Light Valley Solar

Change Application and Consultation Report

Document Reference: EN0110012/APP/LVS/08.42

October 2026

Project Name
Light Valley Solar

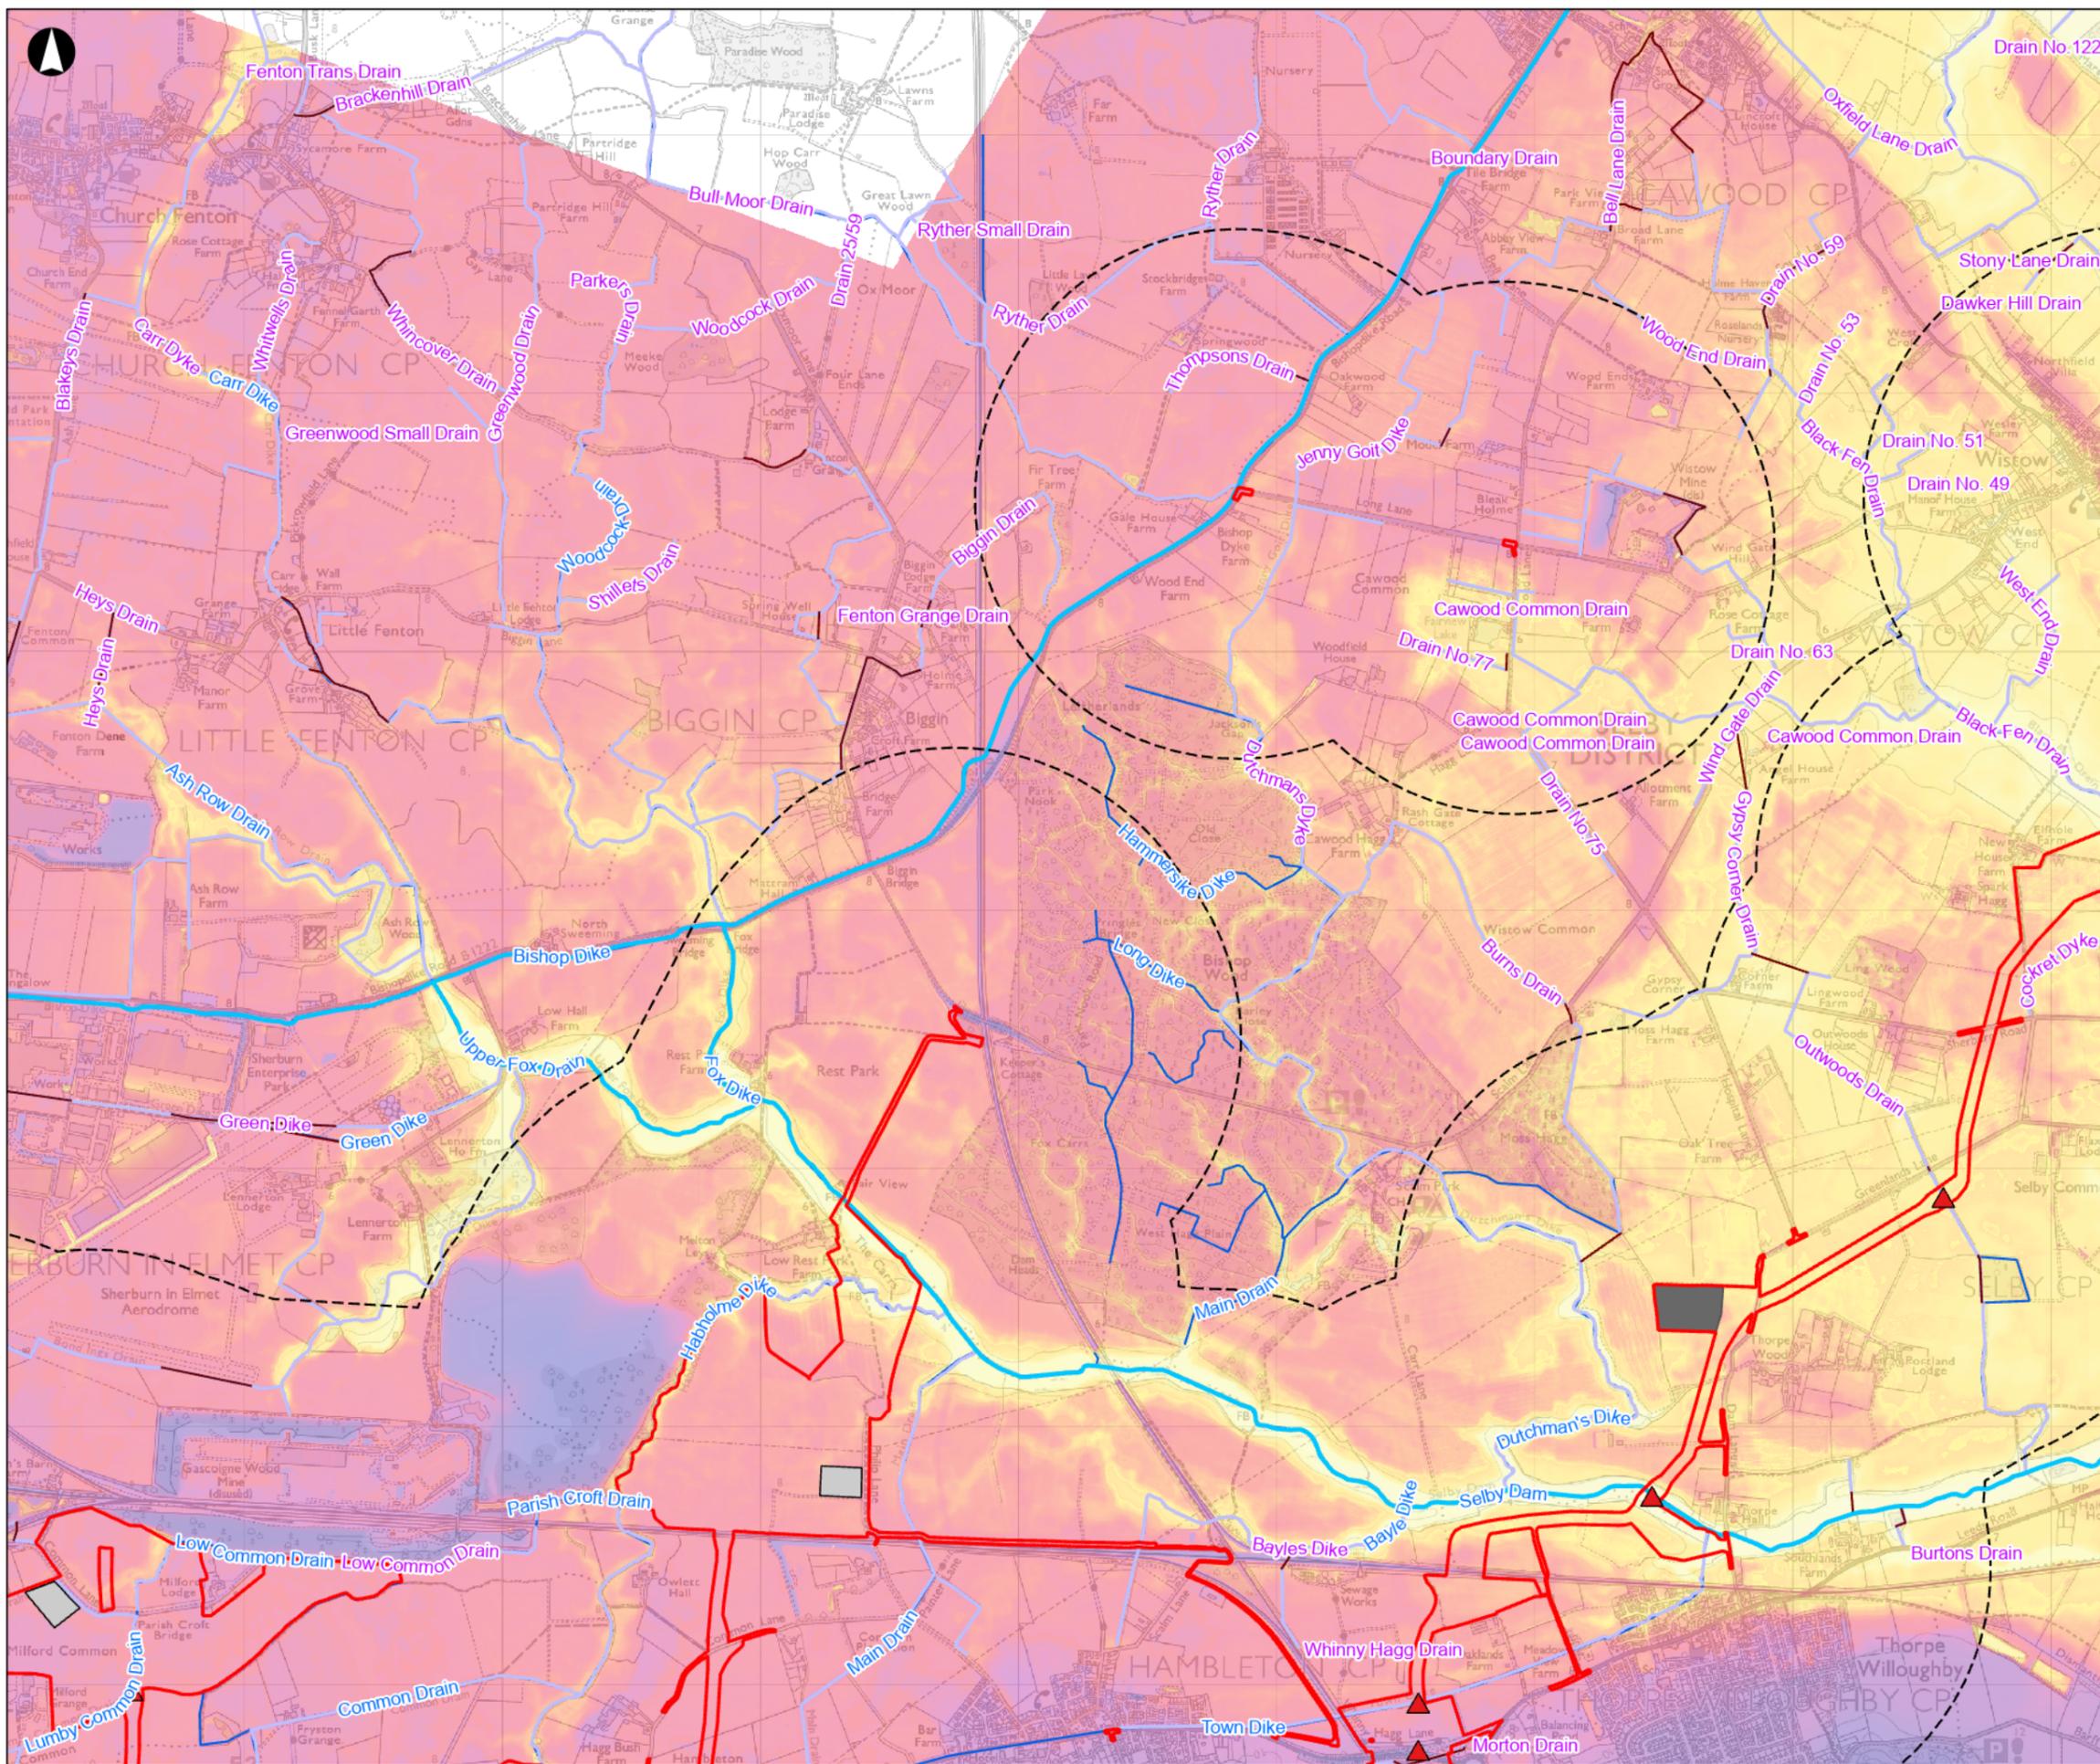
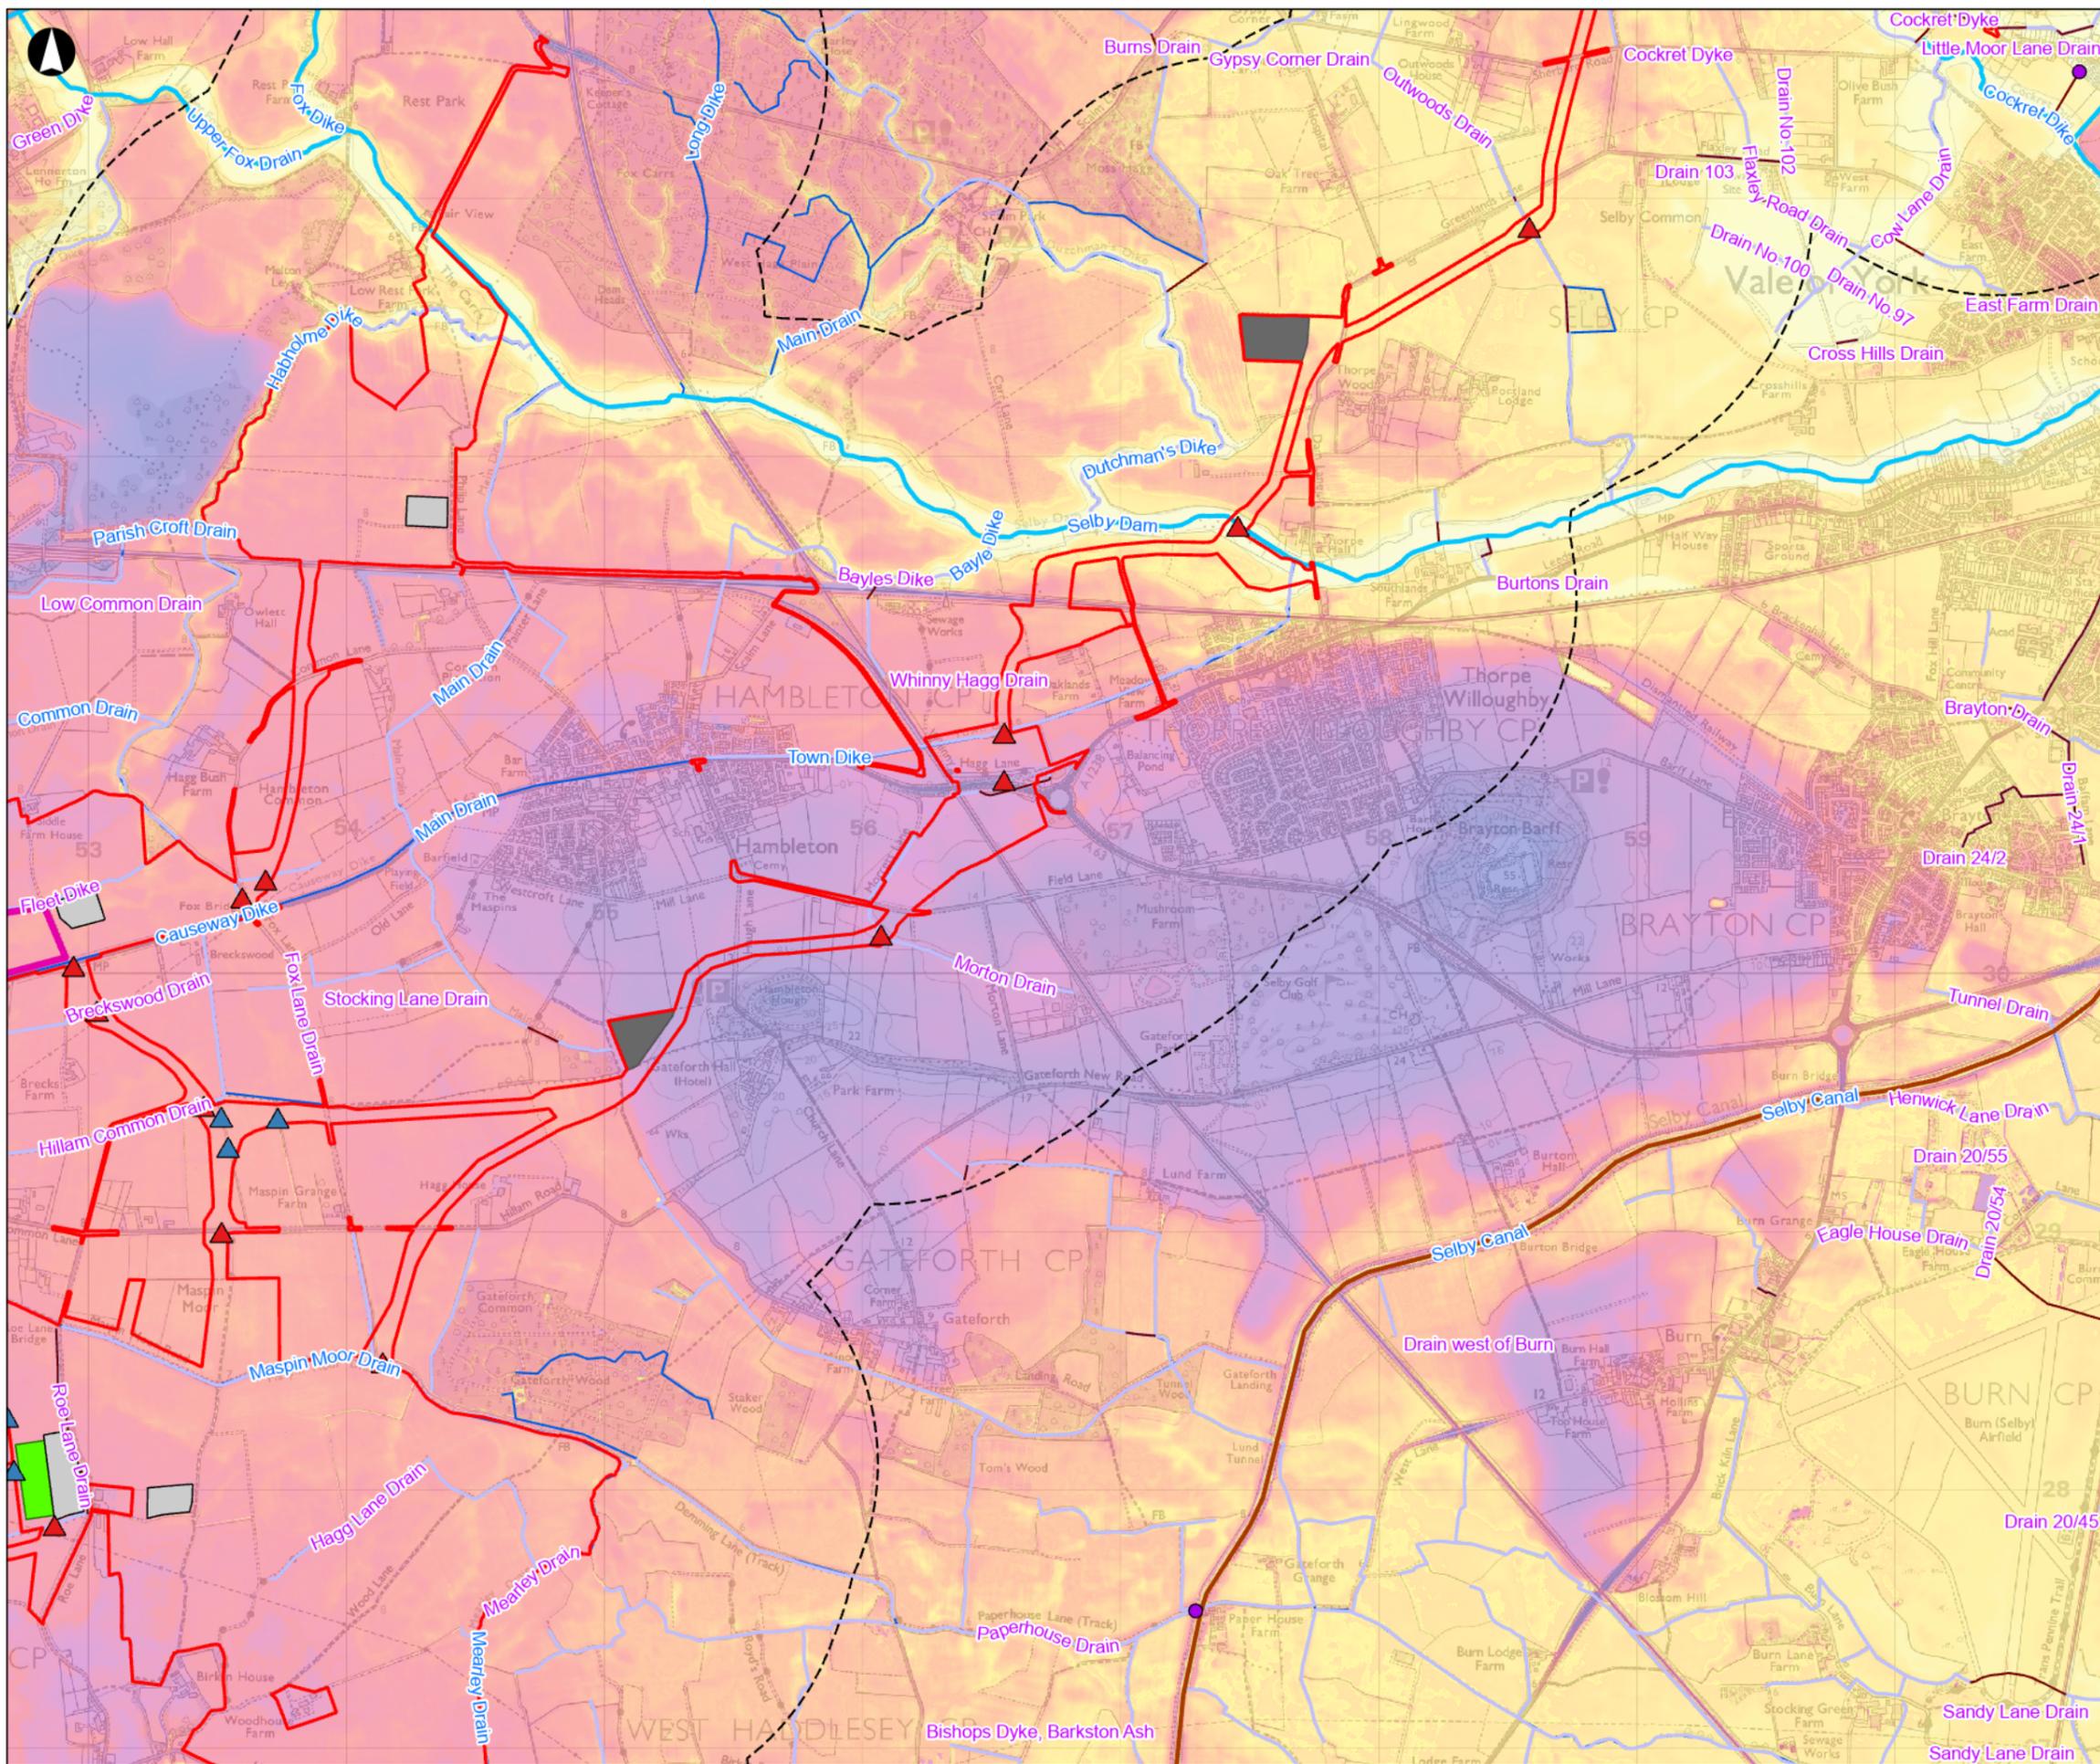
- 3.3.3 As set out within the Applicant Technical Note Plot Size **[REP2-115]**, this section on the Cable Route Corridor is constrained by an Internal Drainage Board Ditch (IDB) ditch (refer to ES Volume 2, **Figure 15.1 Surface Water Features [APP-115]**) which the Applicant has committed to cross using a trenchless solution (refer to ES Volume 2, **Figure 2.5 - Avoidance Areas [APP-062]**). The breadth of the Cable Route Corridor in this location allows for micro siting of the cable and trenchless works during the detailed engineering design work. The Order Limits also captures an existing culverted crossing in the west of the Cable Route Corridor which would be used for access where practicable, rather than introducing new temporary culverts.

- 3.3.4 Subsequent analysis has identified that full width of the Cable Route Corridor north of the IDB ditch is not required for laying of Interconnecting Cables, but this area is still required to facilitate construction vehicle access. Change 7 therefore comprises a reduction in the Works No.5 area and an increase in Works No.8a to reflect this, whilst also facilitating a reduction in the amount of permanent rights required (and thus downgrading to temporary possession only powers to be sought).
